From: Erika Davies
Sent: 24 June 2021 13:26
To: [REDACTED]
Cc: ENC PLANNING
Subject: FW: Planning Application NE/21/00973/LBC & NE/21/00972/FUL

Proposed Plans & Elevations

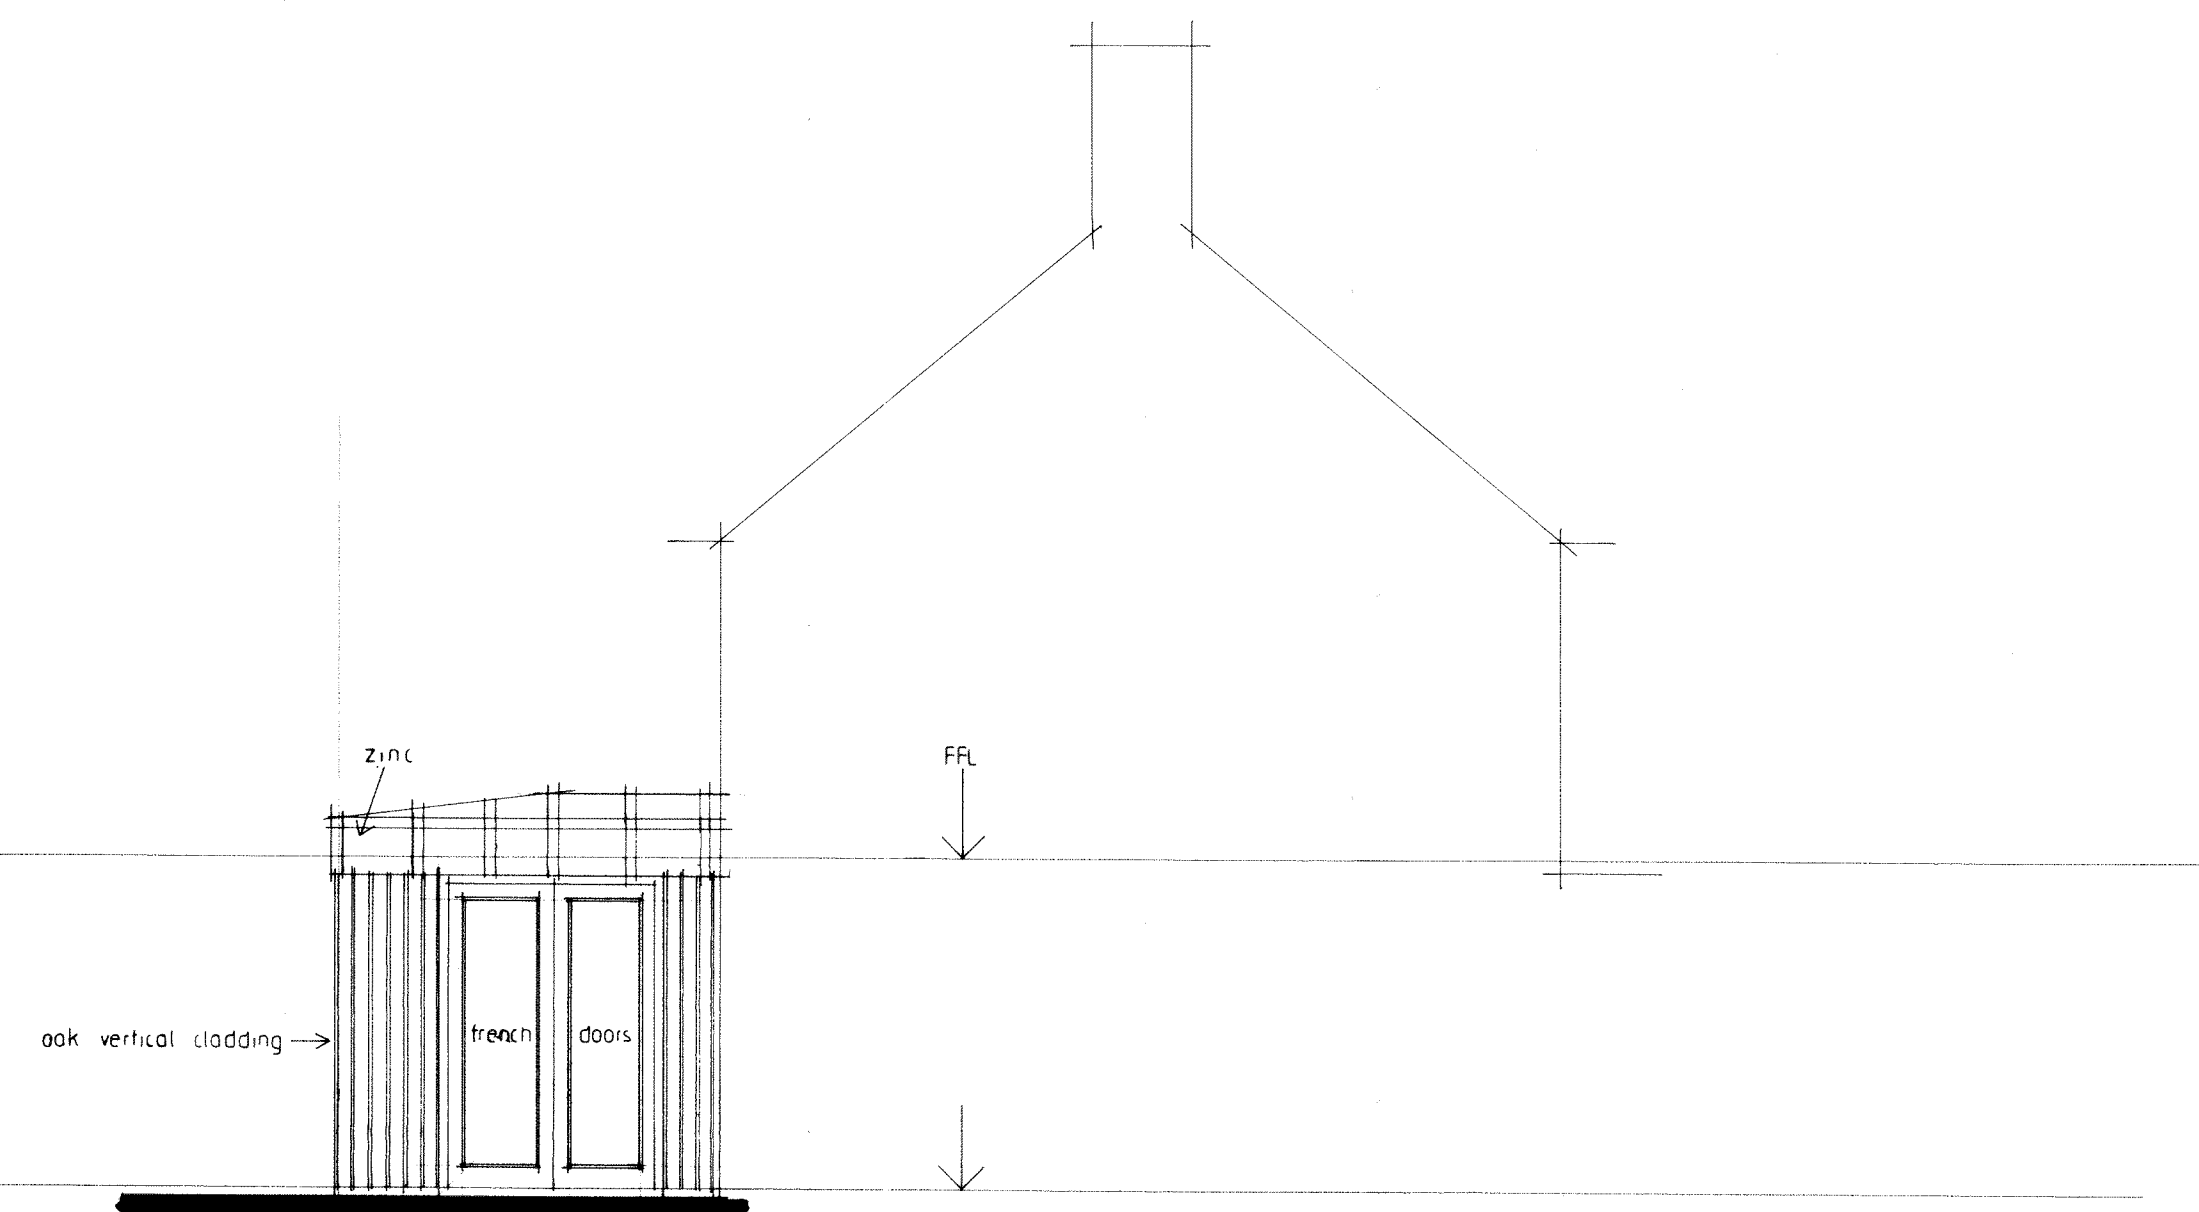
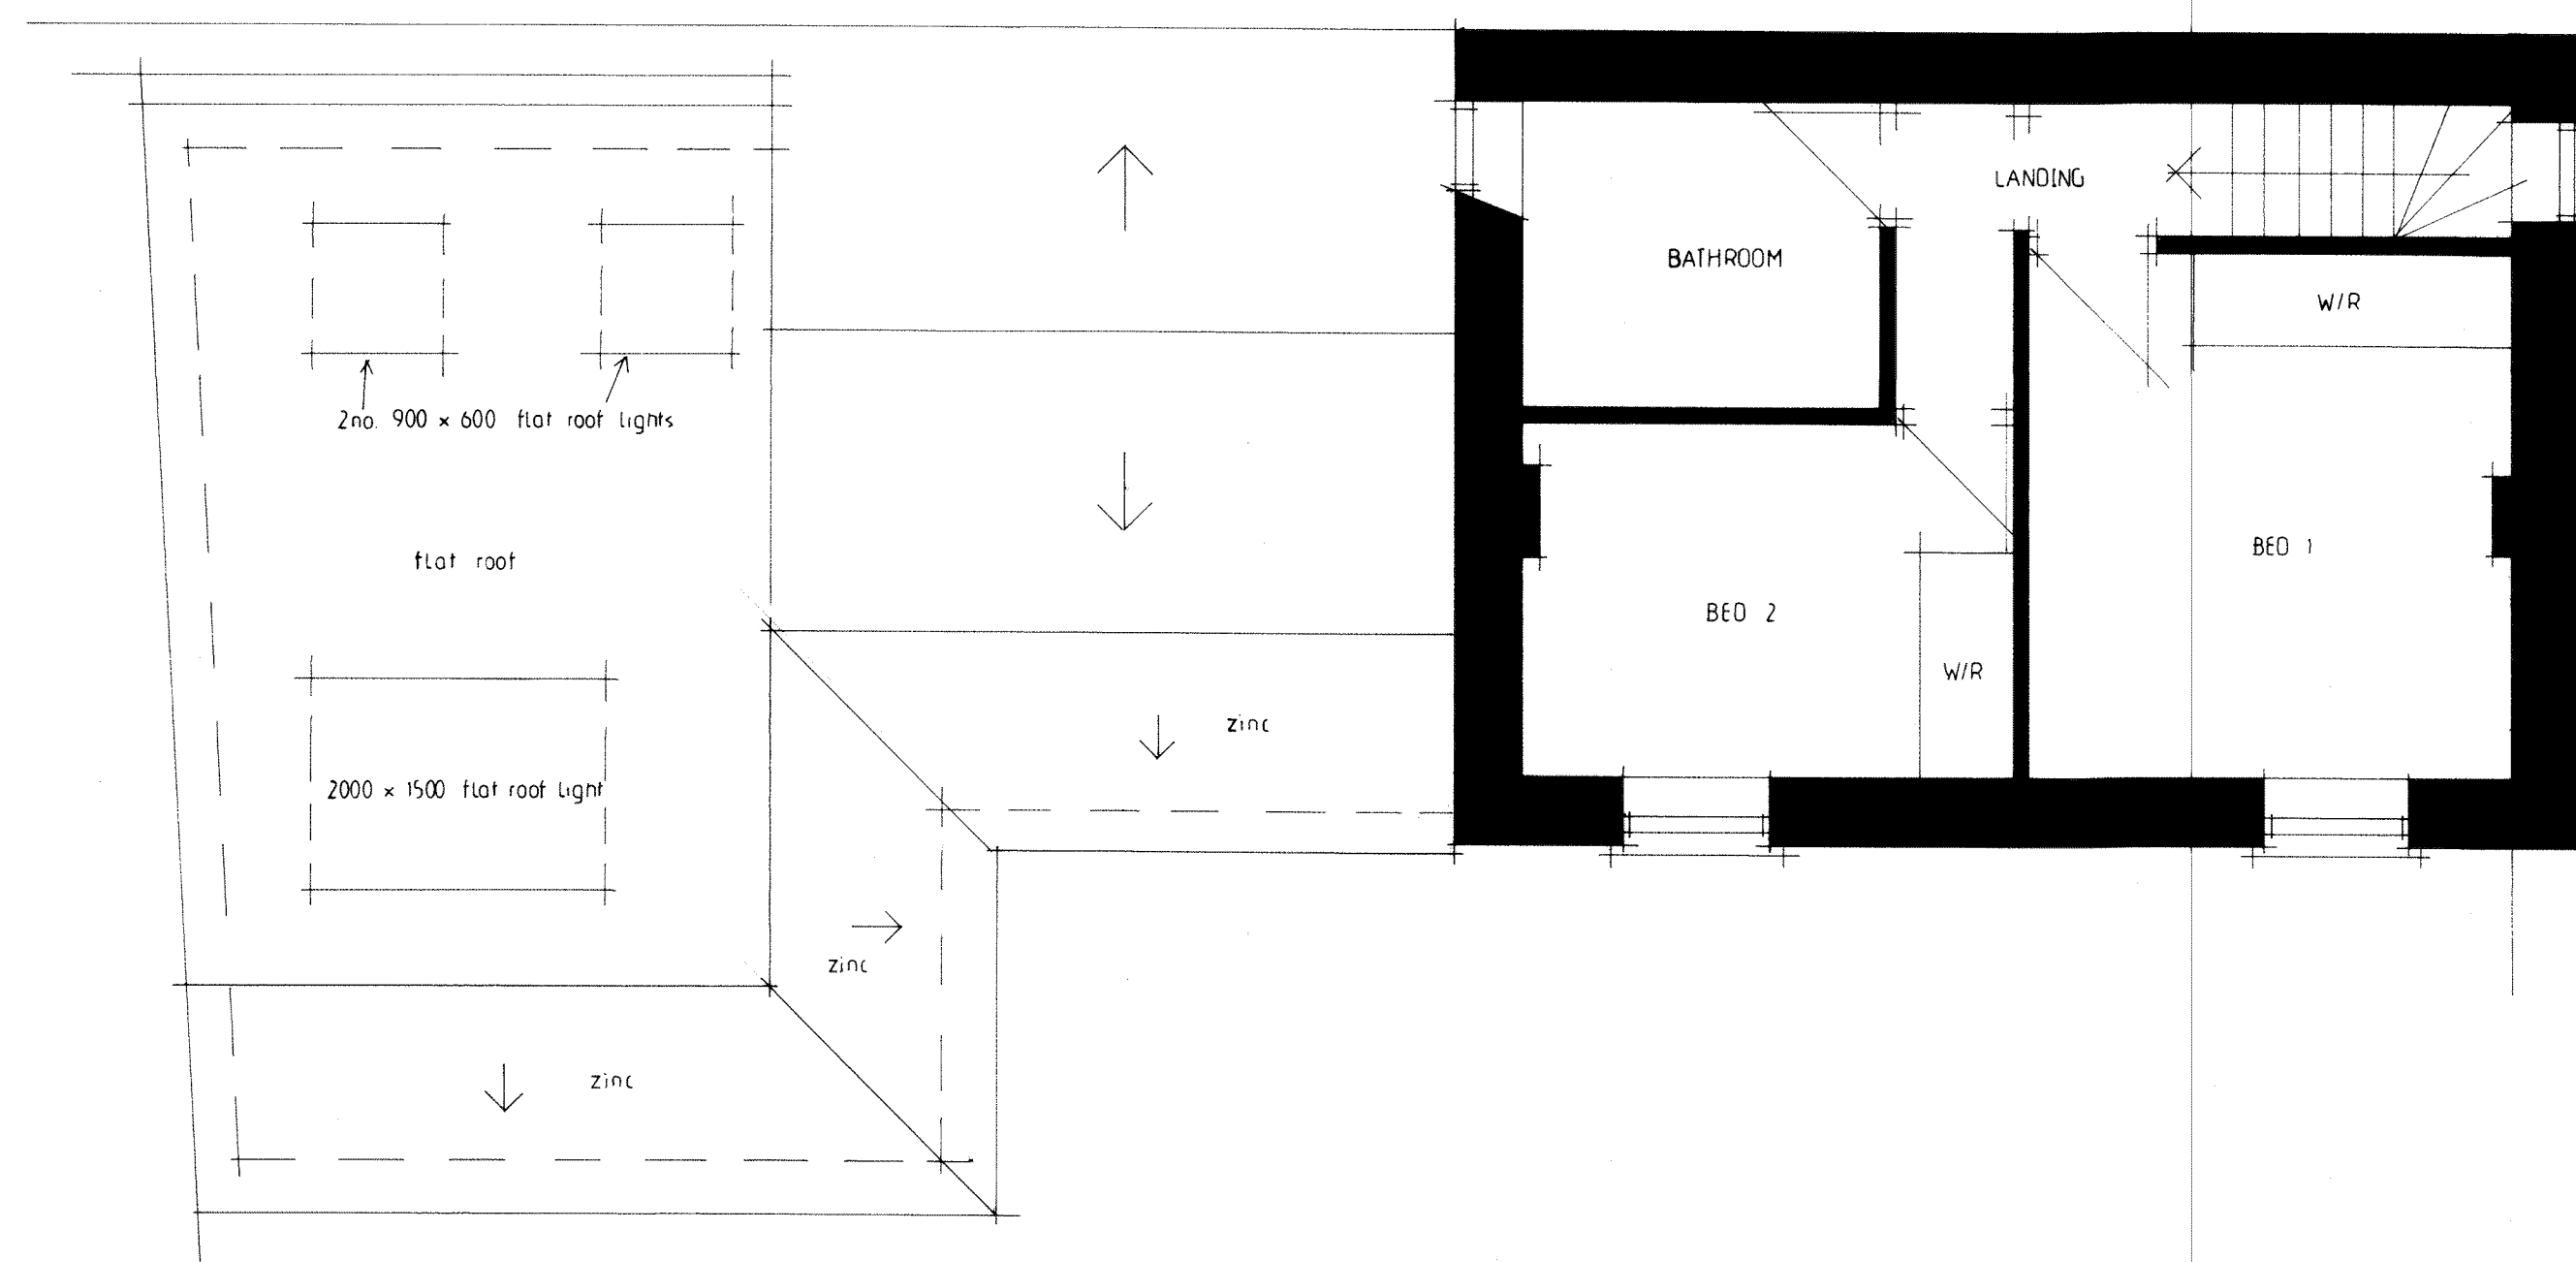
Thank you for the amended location plan and for the drawings with added dimensions, the elevational dimensions appear to measure correctly, however the depth of the proposed extension annotated as 7050 when measured to a scale of 1:50 measures 7513, also the width stated as 3400 when measured to the given scale comes up as 5280

Can these please be corrected as all measurements need to be accurate when viewed online, this is required as all our consultations are done electronically
